Project name	Wykham Park Farm, Banbury		
Design note title	Response to LLFA Reserved Matters Planning Comments		
Document reference	WPF-HYD-XX-XX-RP-C-0007		
Author	Robert Parker		
Revision	P1		
Date	25 May 2021	Approved	✓

The following technical note has been produced following a consultee response from Oxfordshire County Council LLFA, dated 14/05/2021. The consultee response is in relation to a reserved matters (RM) planning application for the spine road and associated infrastructure for the development at Wykham Park Farm, Banbury (Planning Ref: 20/03702/REM).

TYPICAL SPINE ROAD (RD-01A & RD-01B) CROSS SECTION
BITUMINOUS CONSTRCTION

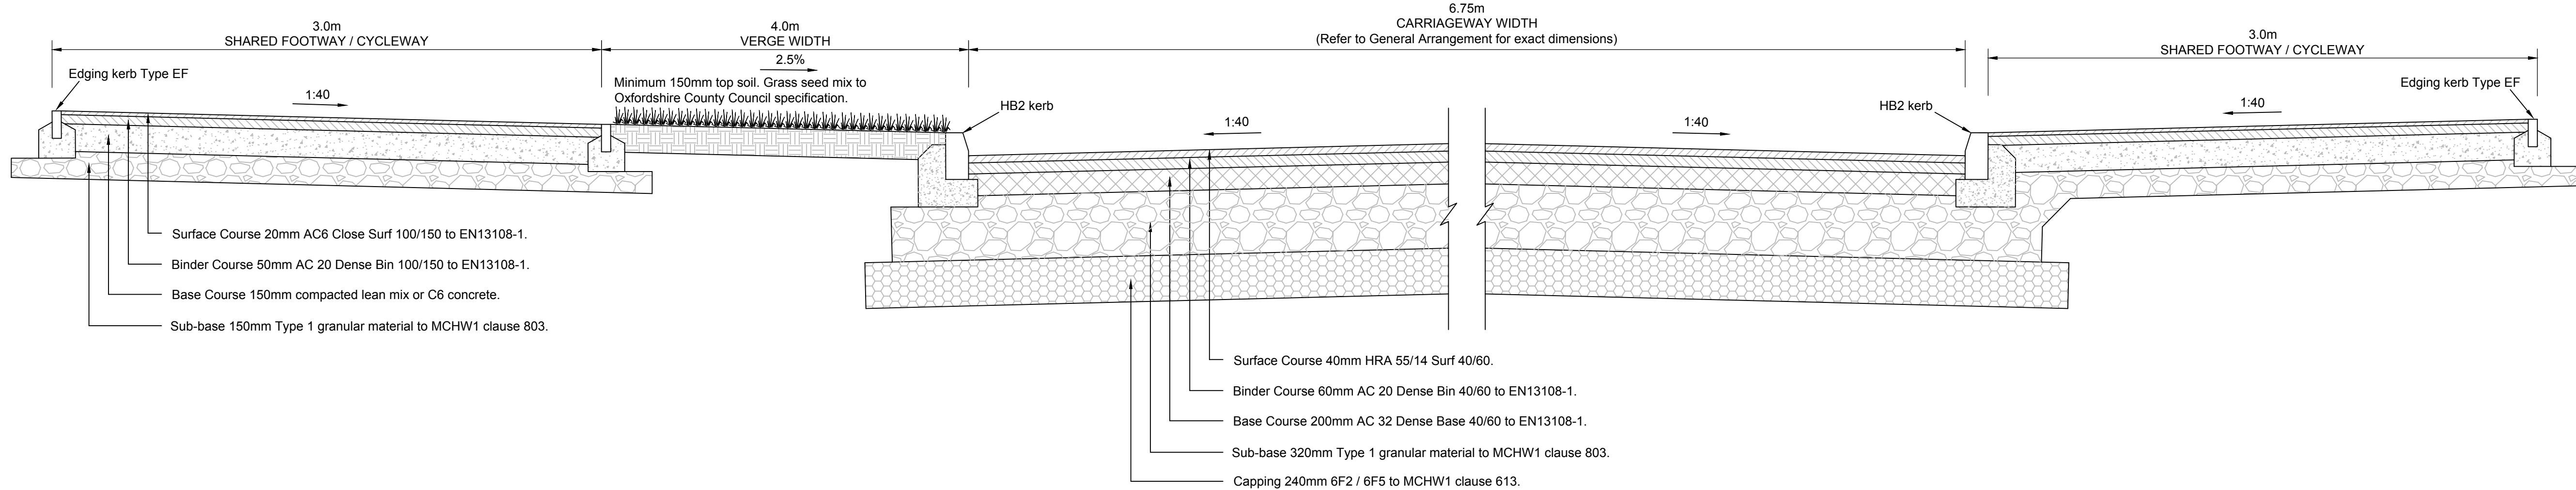
With the scale of site, LLFA believe more SuDS can be implemented at source adjacent to the carriageway. The width of carriageway proposed has more than enough capacity to accommodate SuDS such as filter drain and swales.”

Tree planting is to be provided within the Spine Road's northern verge adjacent to the carriageway. This will provide the visual amenity of the highway corridor by softening the hard surfaces of the built environment.

- The LLFA have intimated that in principle there is sufficient highway width to provide additional SuDS such as filter drains and swales. However, area of verge to the north of the spine road is intended to provide space for visitor parking bays and tree planting. As a result, there is insufficient space in practice to provide either a filter trench or swale within the highway corridor.

TITLE
DRAINAGE LAYOUT
SHEET 2 OF 5

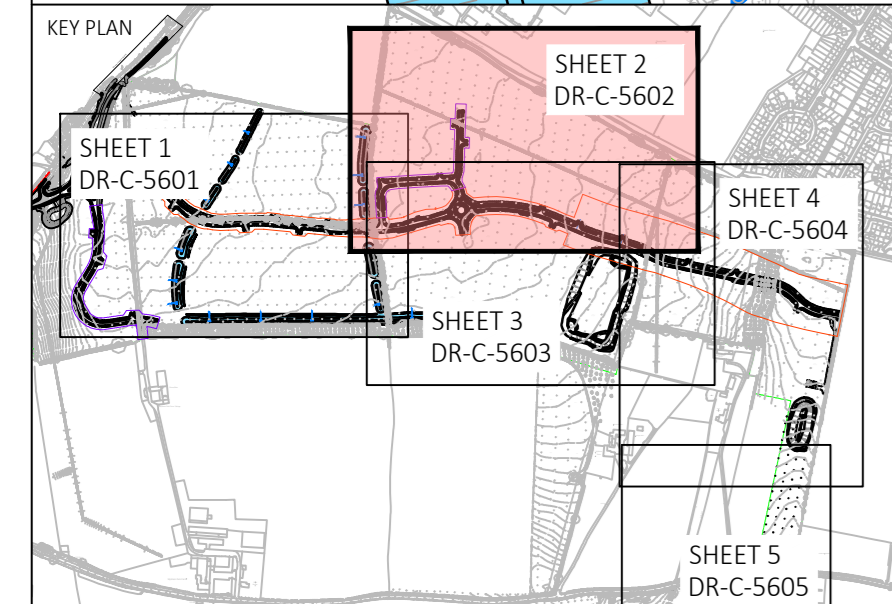
“The LLFA believe the drainage strategy proposed is not in full compliance with Local Standards and Guidance for Surface Water Drainage on Major Development in Oxfordshire.

Surface water flows will be restricted to the greenfield run off rate (QBAR) of 2 litres/second/hectare. Two detention basins and a swale network will provide surface water attenuation for the development. The attenuation has been sized to accommodate run off from future development parcels, as well as the spine road and associated infrastructure included within the RM application. Further details regarding flow restrictions and attenuation are provided within the drainage strategy report WPF-HYD-XX-XX-RP-C-0003.

The inclusion of detention basins and extensive swale networks within the drainage strategy supports opportunities to provide an amenity benefit to the development. Leisure routes have been incorporated within the swales as indicated on drawing WPF-HYD-XX-XX-DR-C-2101. Furthermore, a leisure route will also be positioned adjacent to the detention basin.

- It is considered that the inclusion of an additional swale or filter trench will not have a discernible impact on the four SuDS principals / objectives. Drainage strategy report WPF-HYD-XX-XX-RP-C-0003 confirms that water quantity and water quality will be addressed by the provision of the swale networks and detention basins. The inclusion of an additional swale or filter drain will have no practical amenity or biodiversity benefit, and therefore can be considered superfluous to requirements.
